PLANNING DEPARTMENT – Development Review Services

September 30, 2016

**RE: Albuquerque Biopark Zoo Penguin Exhibit
Grading & Drainage Plan
Engineer's Stamp Date 9-15-2016 (File: K13D034G)**

GRADING AND DRAINAGE PLAN - OVERALL

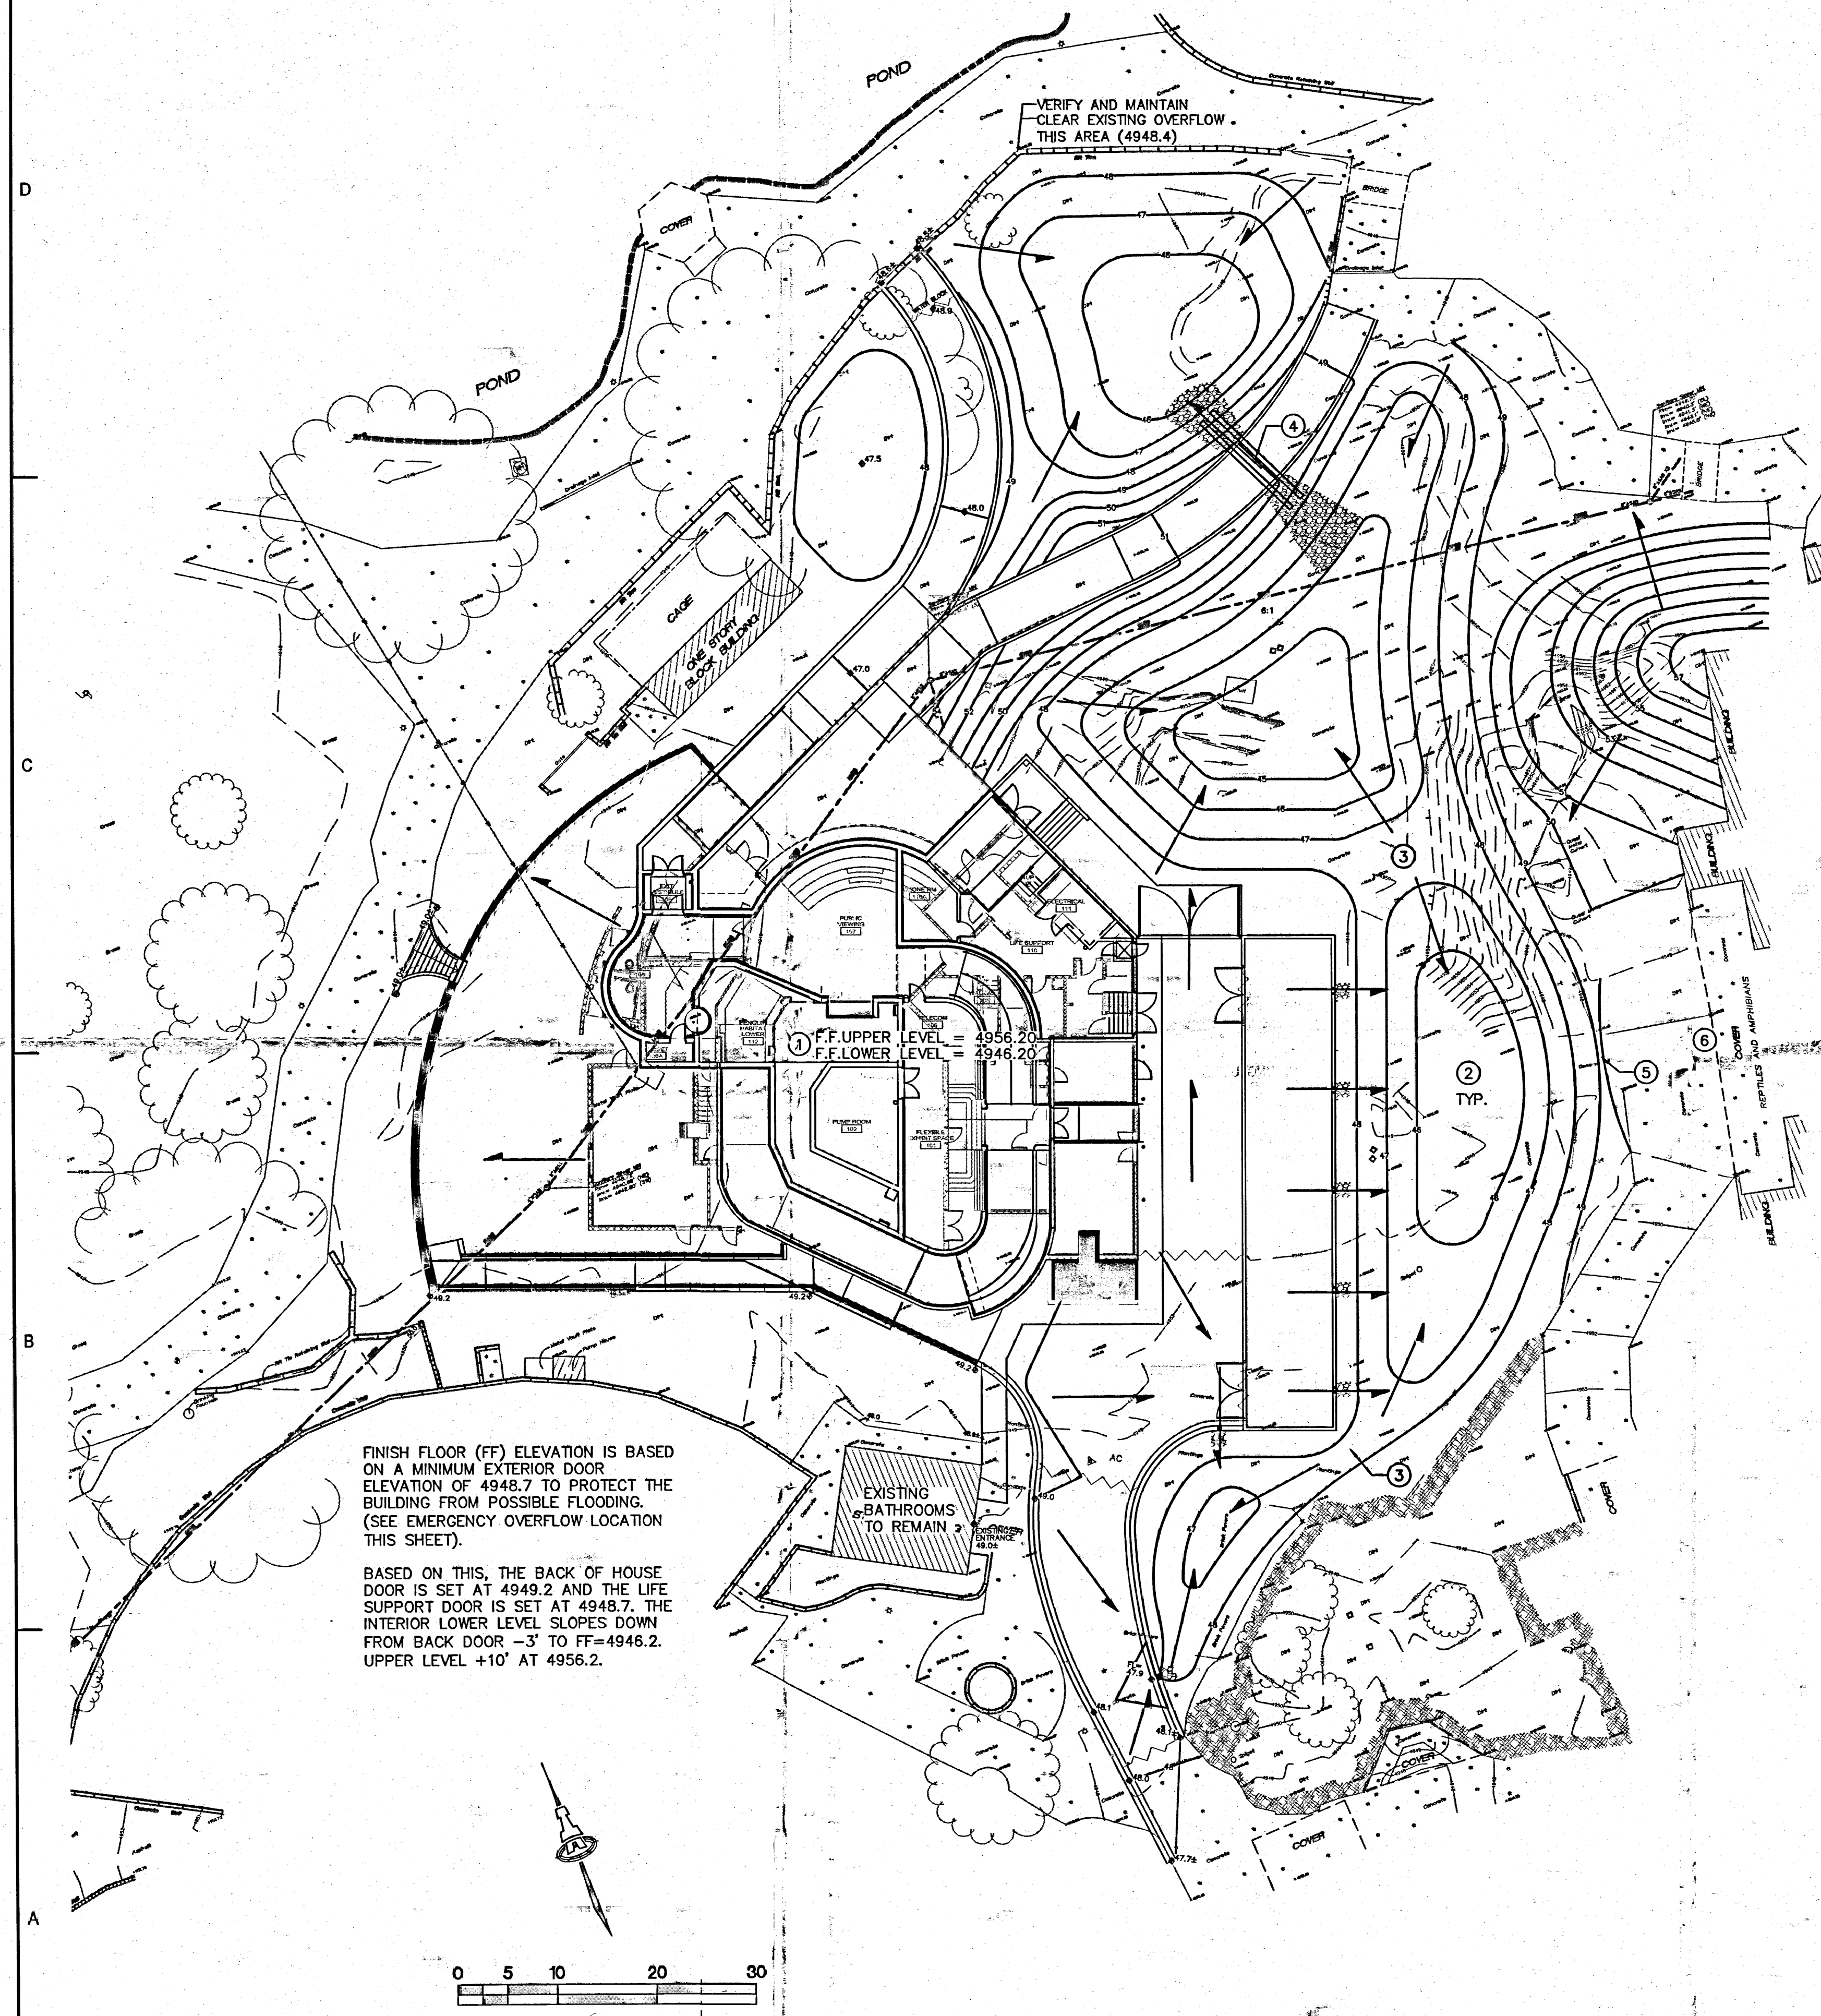
1. Provide an overall plan of the Zoo showing the location of the proposed development, including the pond and park that would accept any overflow of the retention ponds.

2. Provide calculations that show the Max WSE of the retention ponds (use the 10 day storm for permanent retention ponds per DPM). Show the MWSE on the plan.

5. Provide a basin map.
6. Contact Jane Rael (505-289-3439) at the WUA to verify that they will in fact accept drainage from the trench drain into the sanitary sewer. If so, ensure that the plumbing sheets show a pipe tied to the trench drain. Provide the Plumbing sheet. (11x17 only)

9. Walkway on the south side shows curb using triple lines. What is the meaning? Provide section cut.
10. The narrative states that the previous drainage scheme is being used, but the existing contours do not reflect previous ponding. Please clarify.

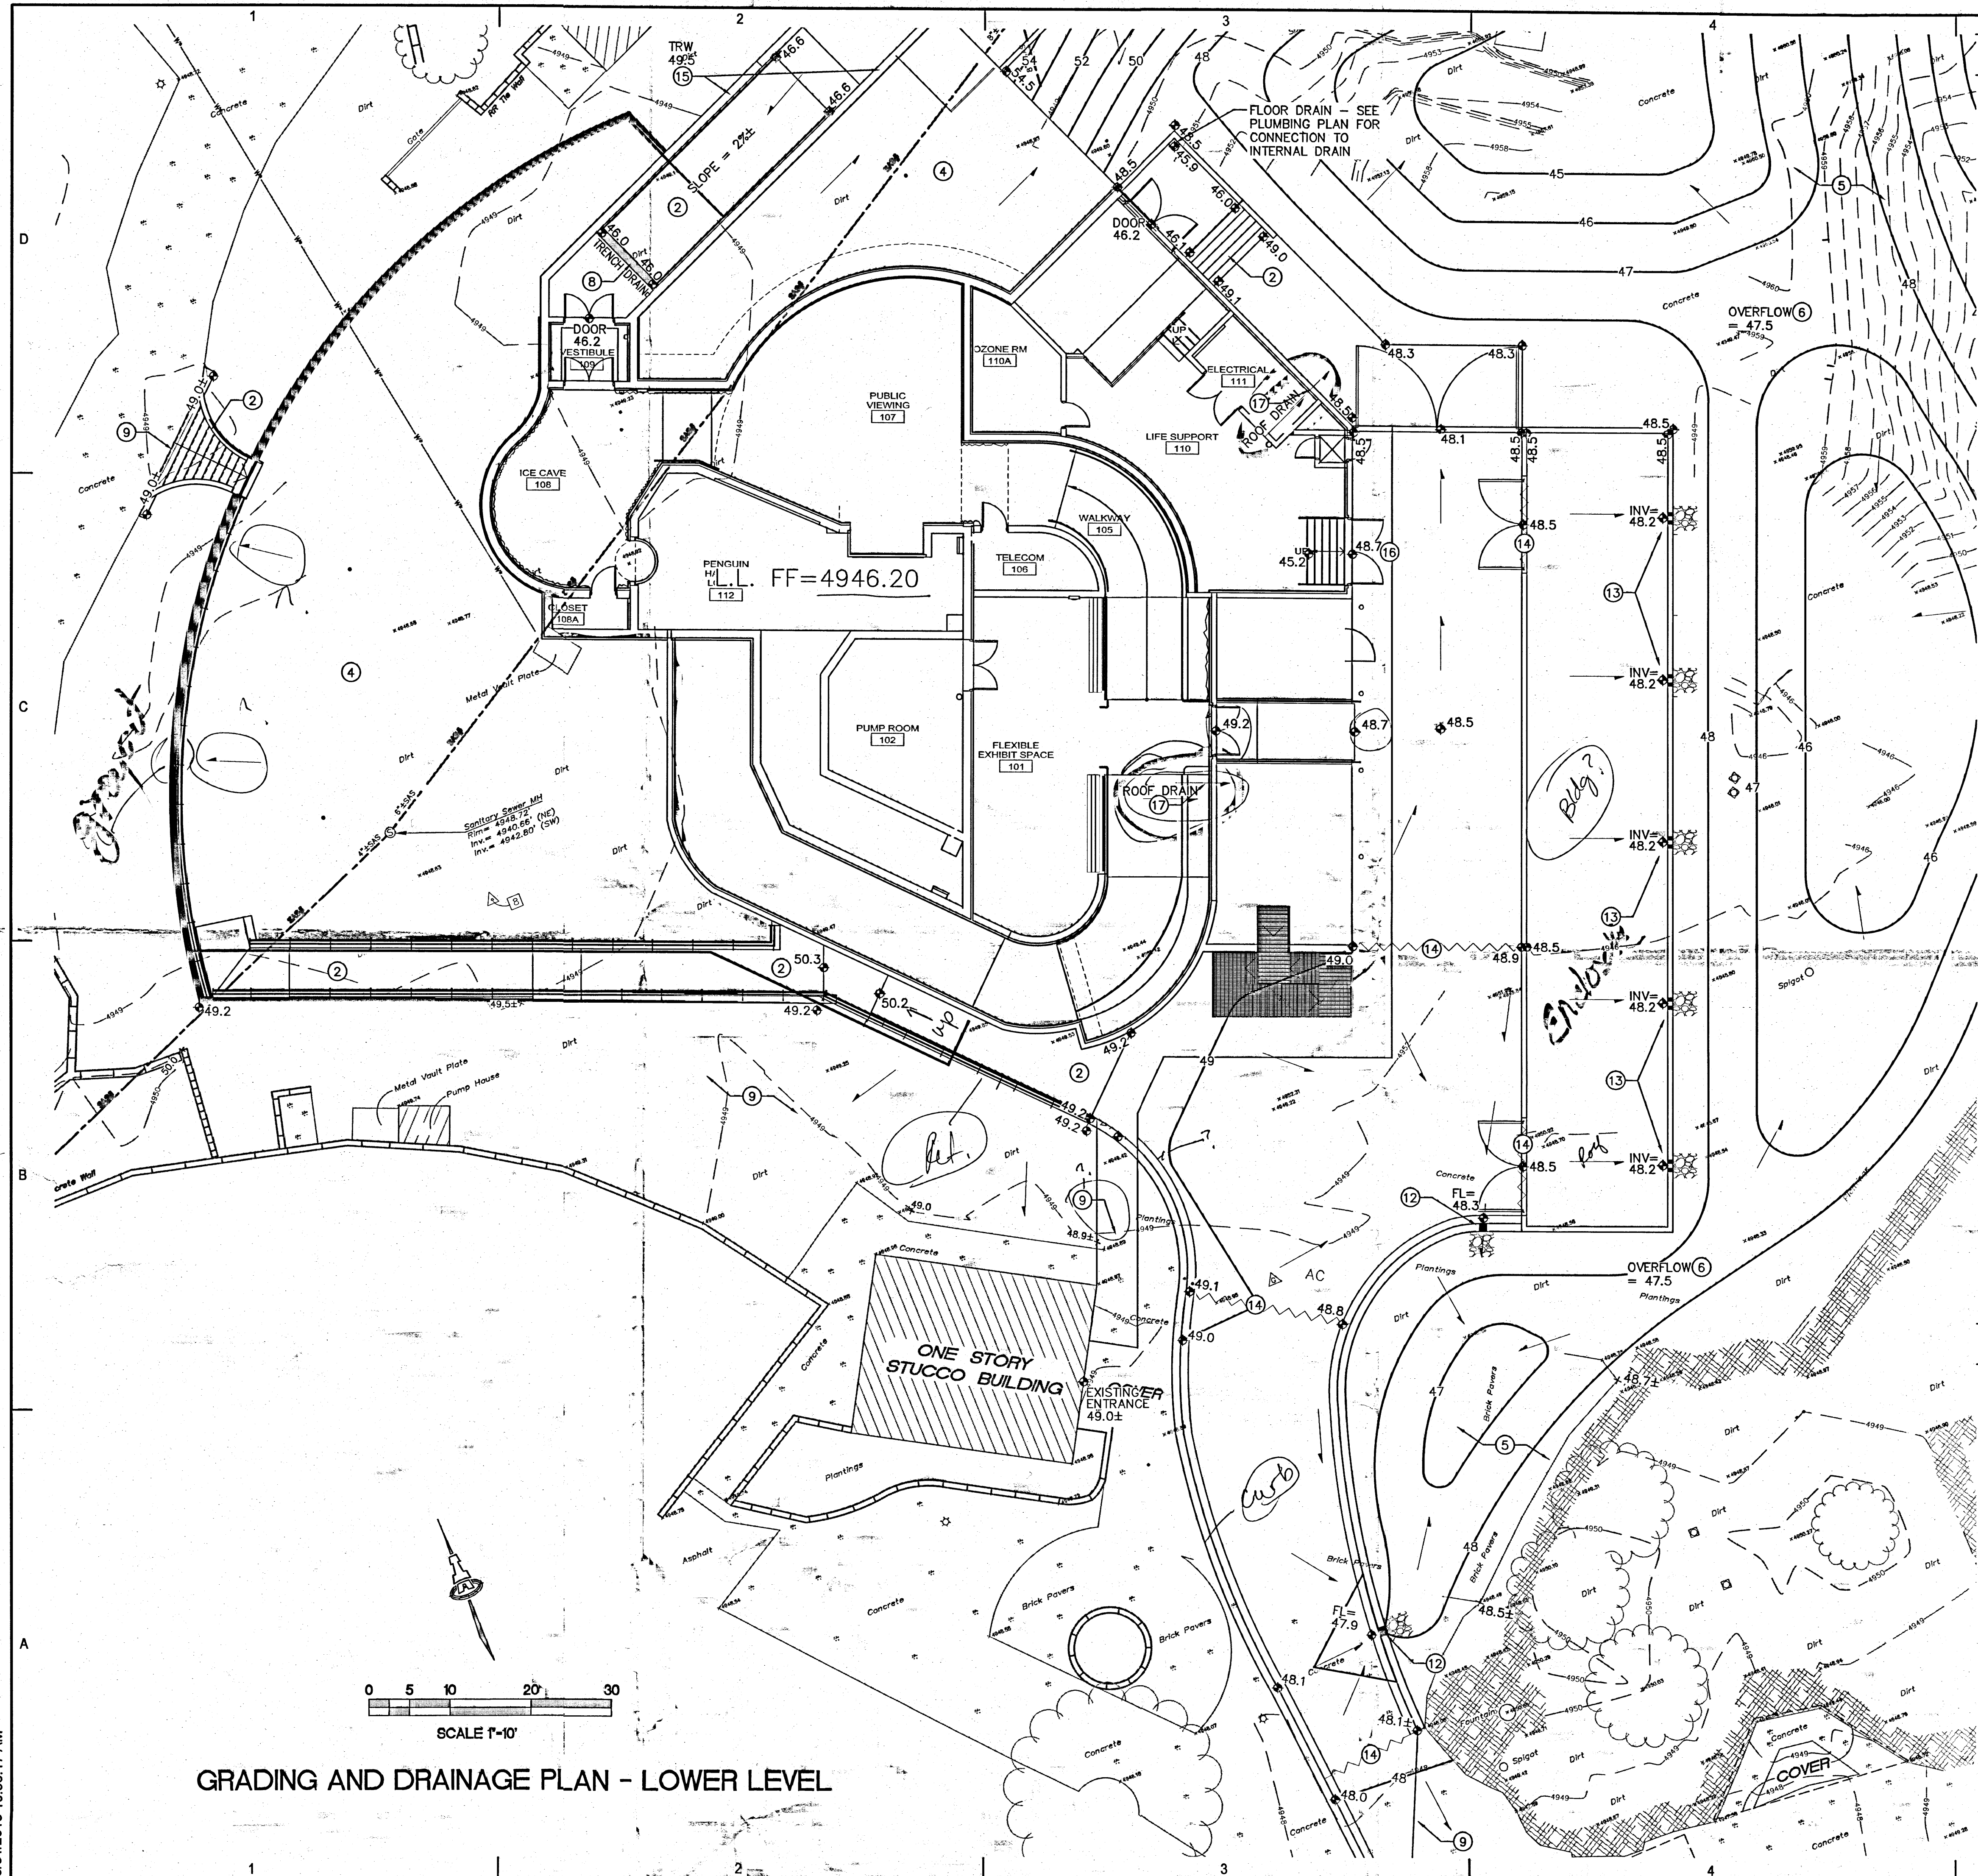
3. Clarify the location of all retaining walls and note which walls are part of the architectural plan set and which walls are part of the Civil plans. All retaining walls need to show the Top of Wall and Bottom of Wall elevation.

4. Verify that the Zoo is willing to accept drainage discharging over the retaining wall. This seems very unusual since such discharge will stain and erode the wall over time. If this is in fact acceptable, show depressed areas that would collect the flows.
